The permanent stormwater Best Management Practices (BMPs) for The Villas at Claremont Ranch consist of development of a full spectrum extended detention basin located in the northern portion of the subdivision adjacent to Sand Creek. The pond requires 0.139 acre-feet of water quality capture volume and a total (100-YR) volume of 0.760 acre-ft. Catamount Engineering has reviewed the as-built survey of pond, and outlet structure prepared by M&S Land Surveys and performed field measurements of structures. The as-built drawings indicated that the overall pond volume, the pond inlet, and outlet structures were constructed in general conformance with the approved design. The facilities provide the required storage volume and will meet the required release rates (as documented by the attached MHFD design form), the stage areas, elevations, and outlet dimensions.

Project: VILLAS AT CLAREMONT RANCH

PRIVATE EXTENDED DETENTION BASIN
SCALE: 1" = 20'

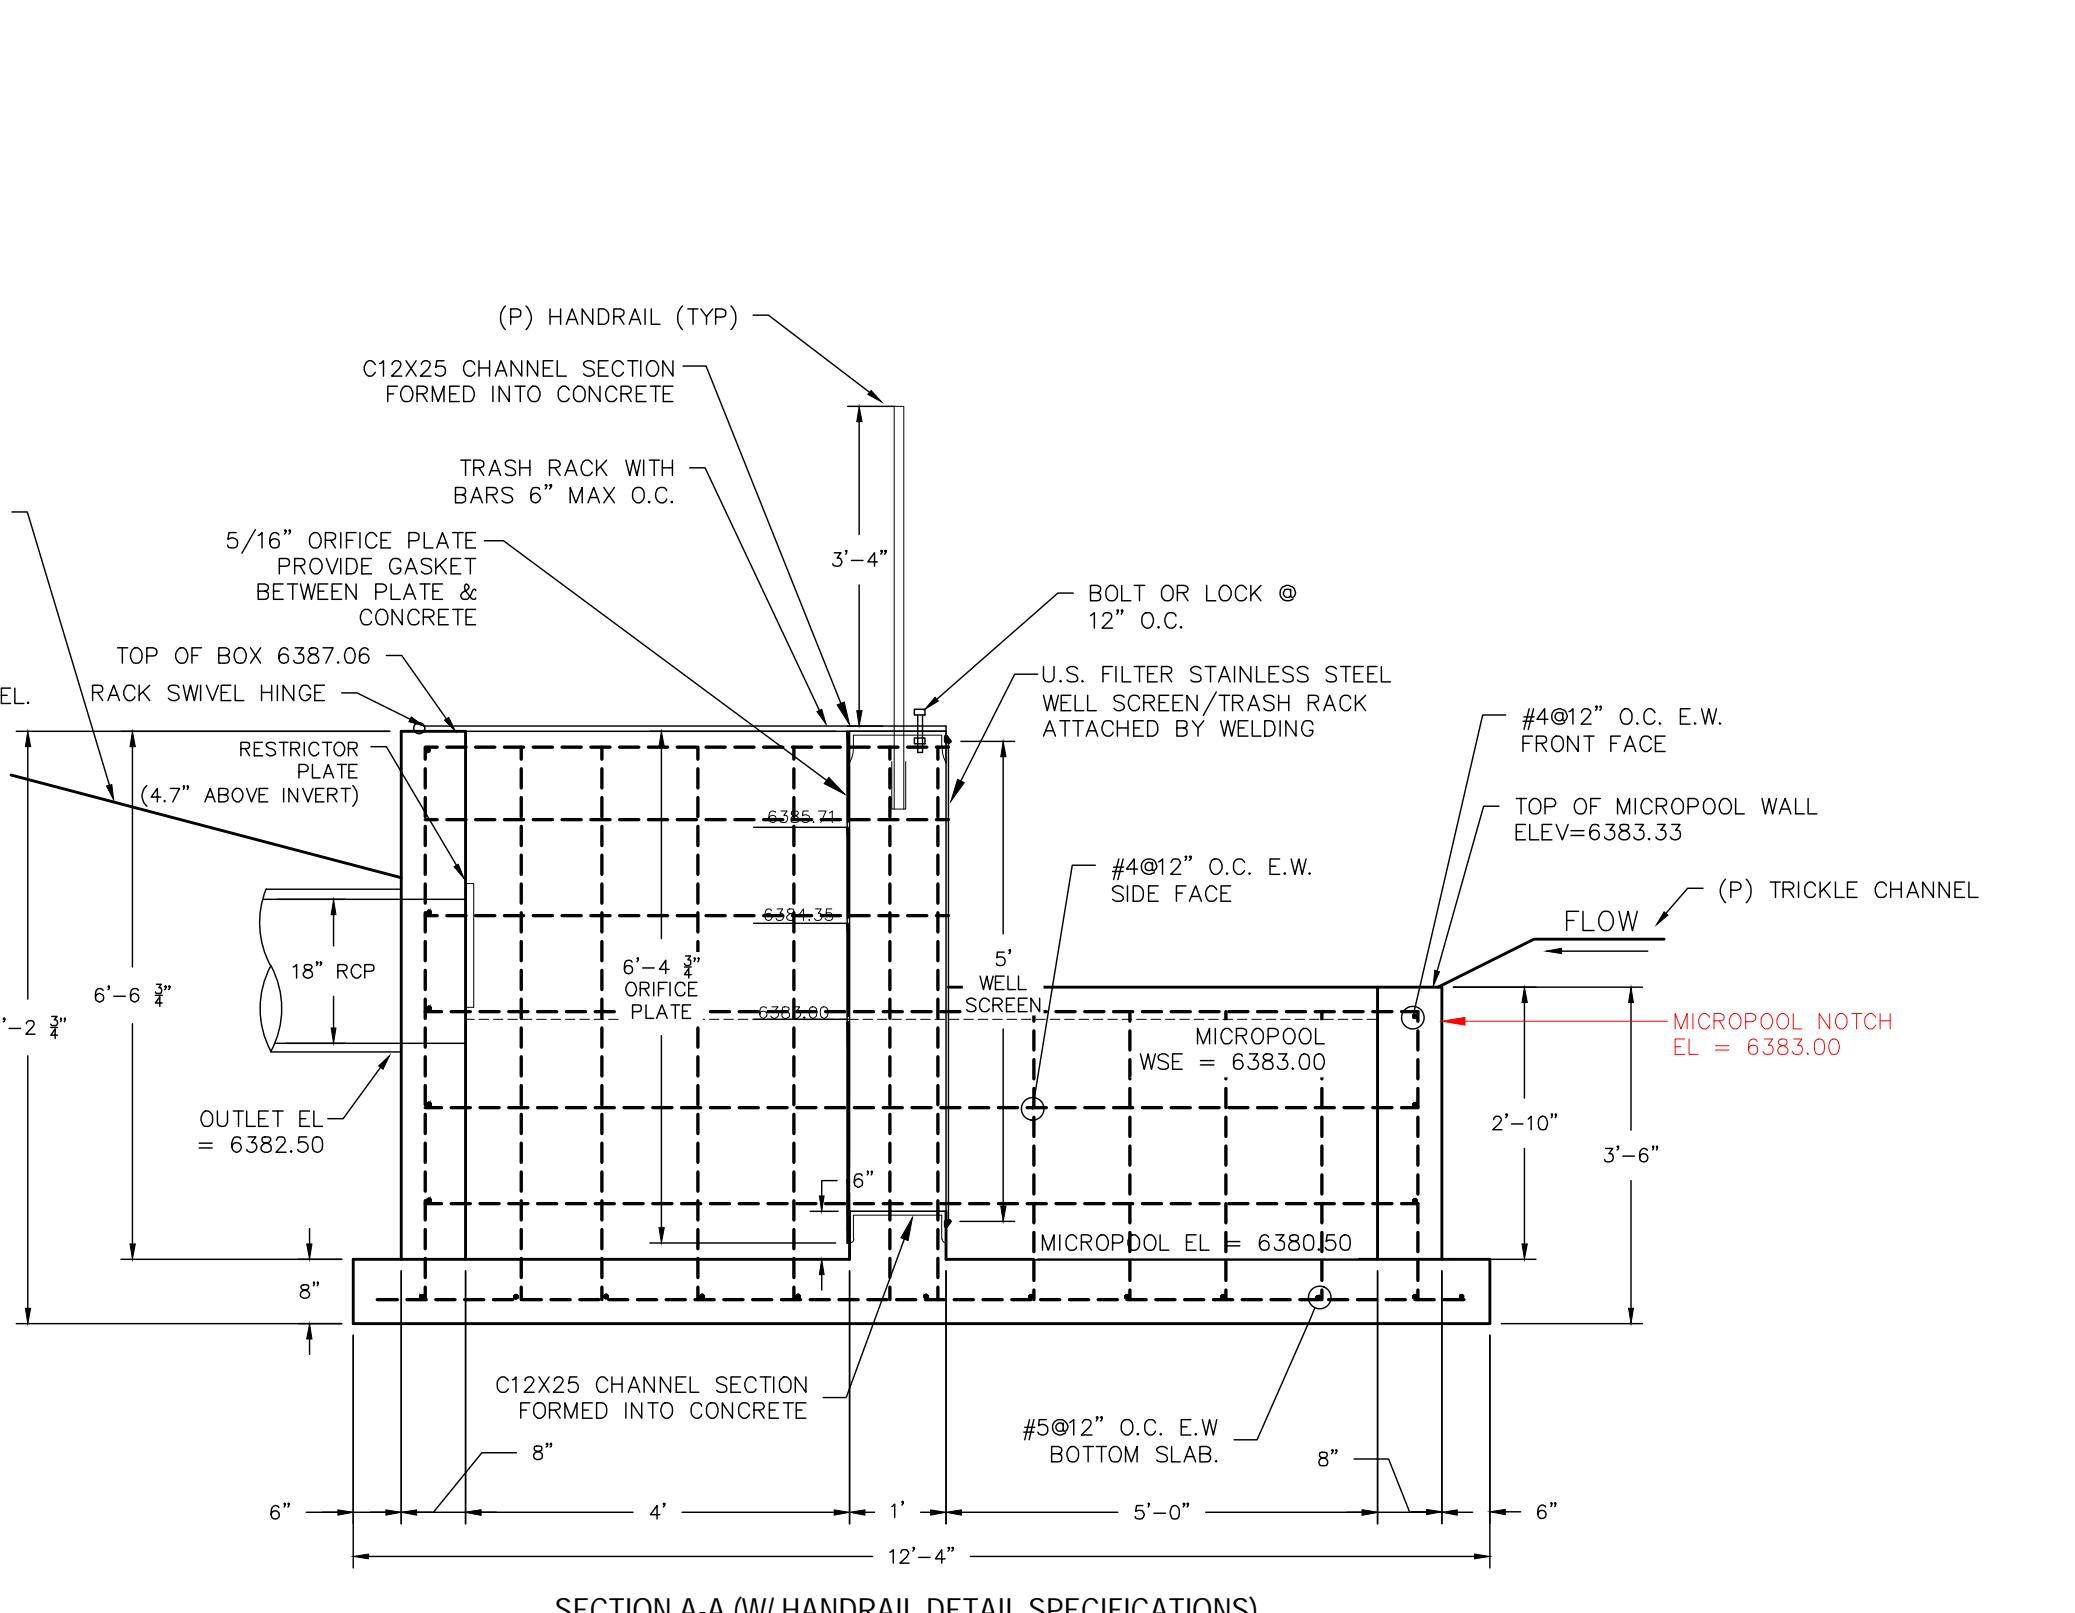
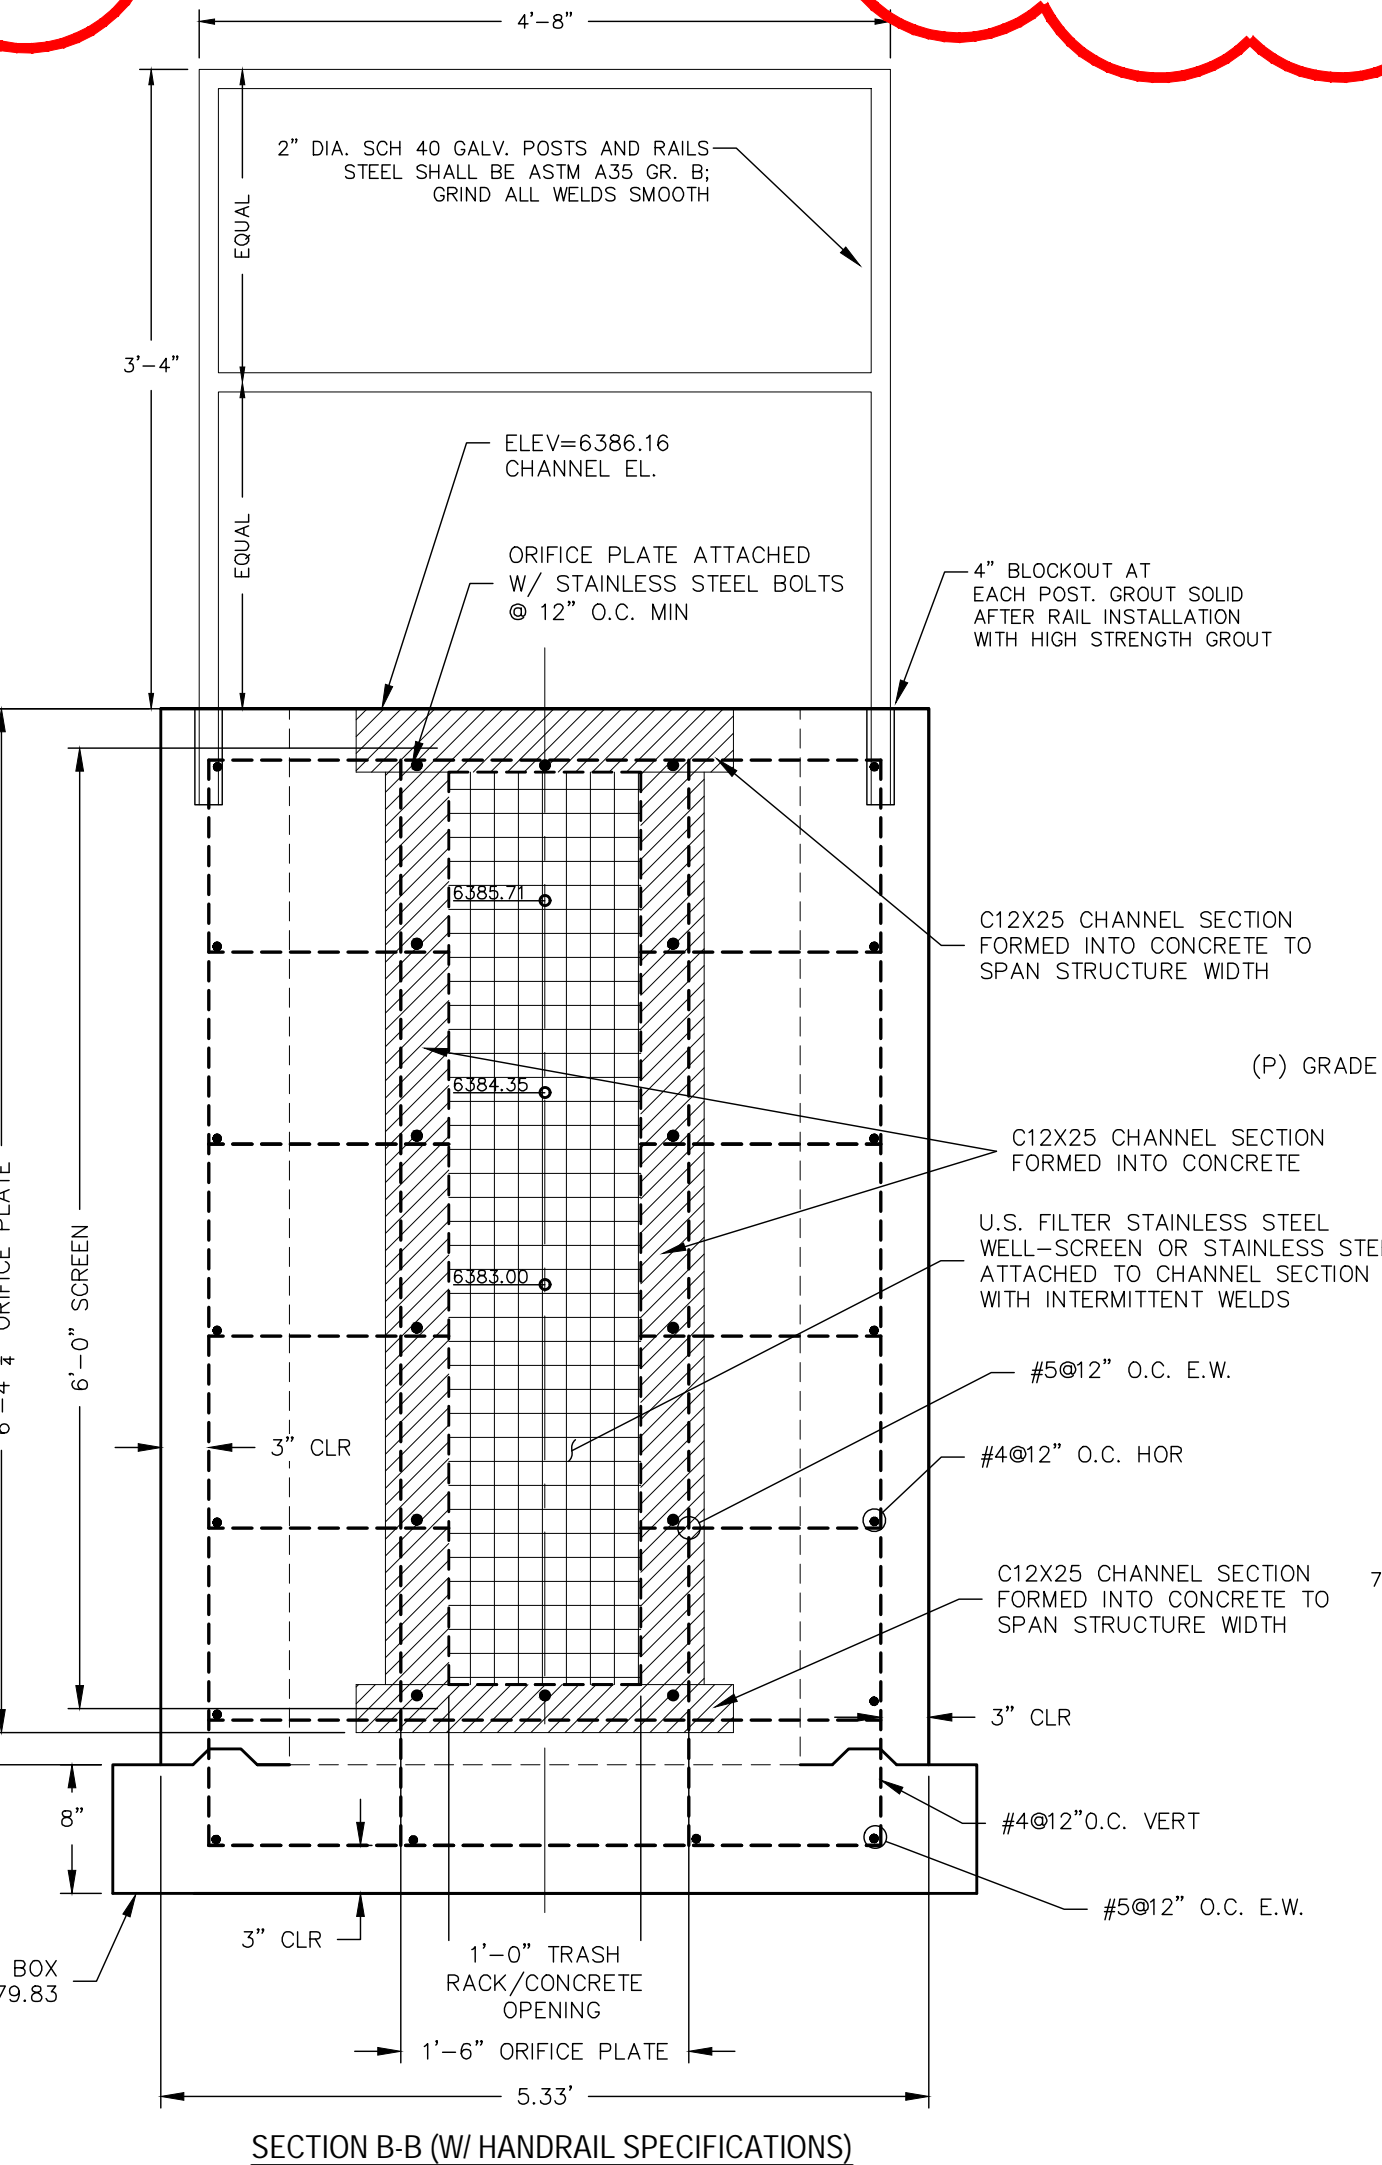
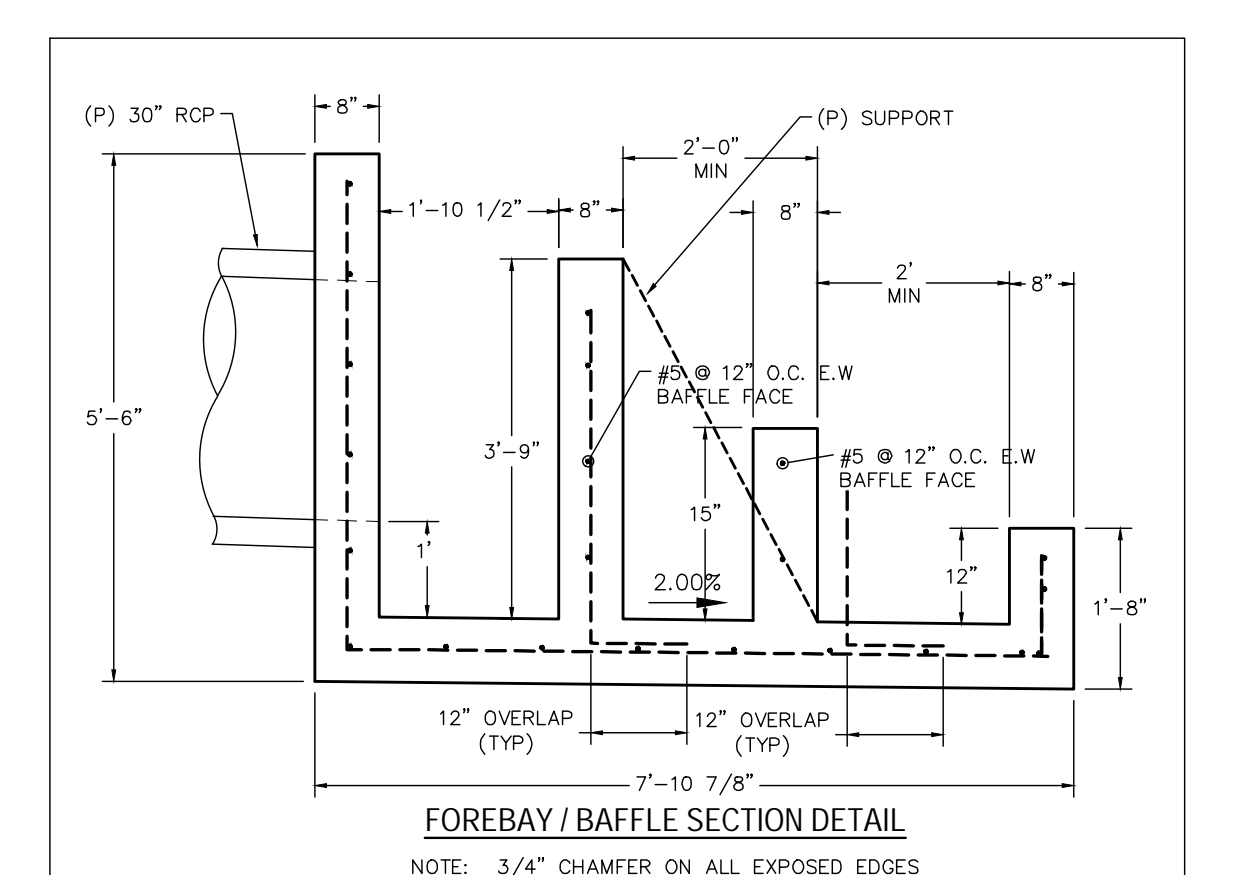
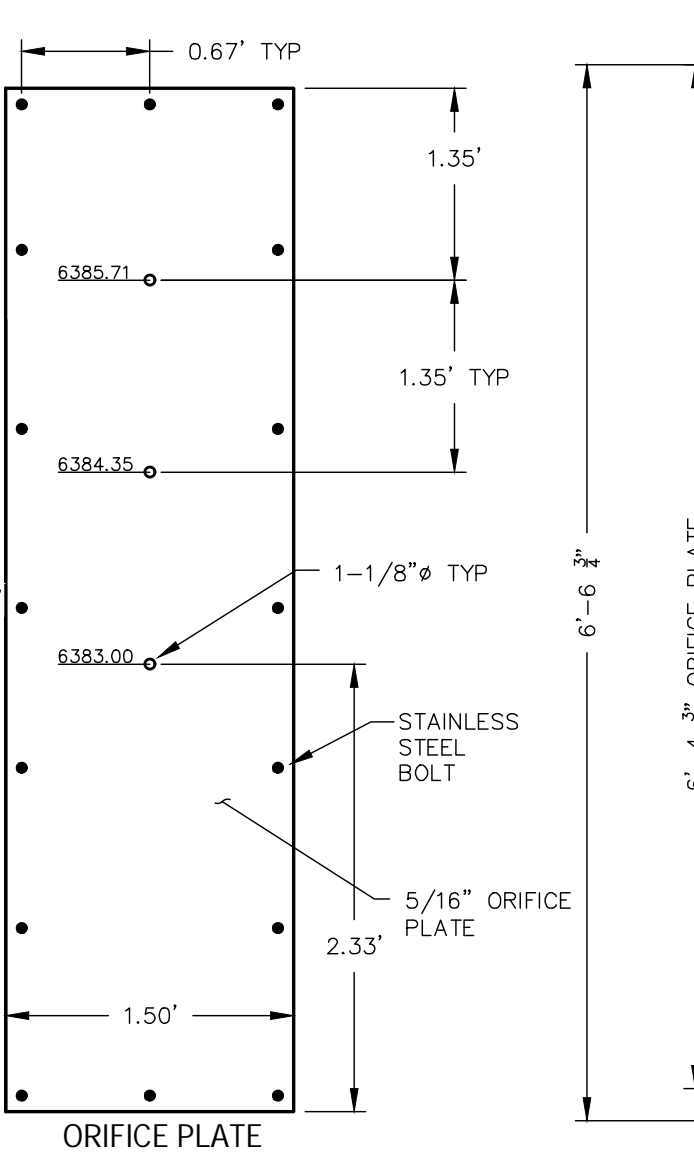
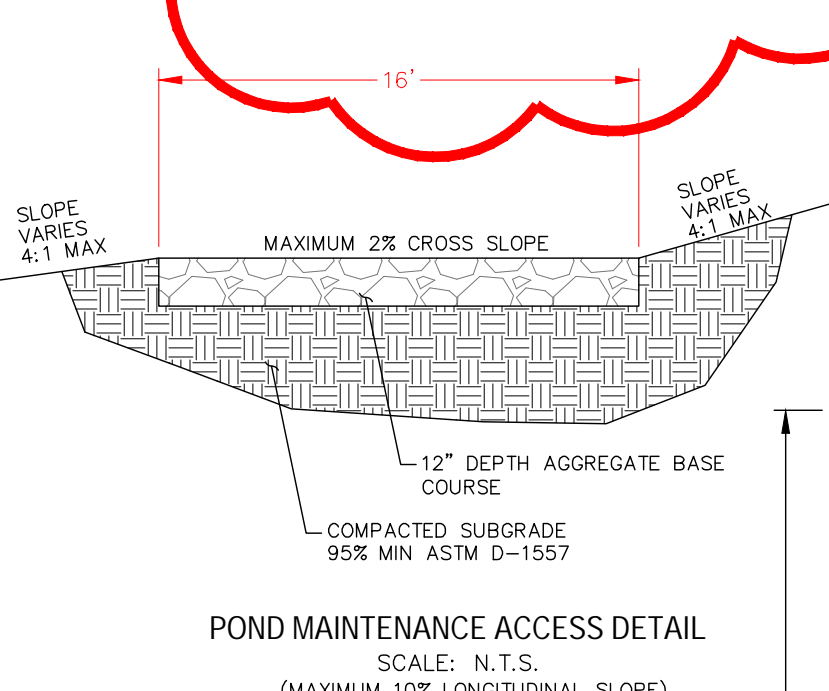
- The approved plans indicated an emergency overflow width of 20'. The emergency overflow was constructed 16' wide with required 4:1 side slopes. The 16' spillway width raises the water surface of the fully plugged overflow condition by 0.04' and adequate berm height exists to maintain the 1.0' freeboard required. The increase in unit flow will not change sizing of required buried riprap.

- The trickle channel was revised to a 1.0' width x 6" deep trapezoidal channel vs. the inverted crown design in the original plan. The original alignment was utilized and the trapezoidal channel was installed at a longitudinal slope of 0.5%. The trickle channel enters the micropool below the lip of the structure (initial surcharge volume) but above the micropool outfall depth.

- The pond outfall location was revised to eliminate crossing of CSU water transmission mains. The outfall maintains configuration of initial design outfalling 1.0' above the toe of the channel bank to a riprap energy dissipator that maintains positive grade in excess of 2.0% to the top of the defined low flow channel in the center of the creek.
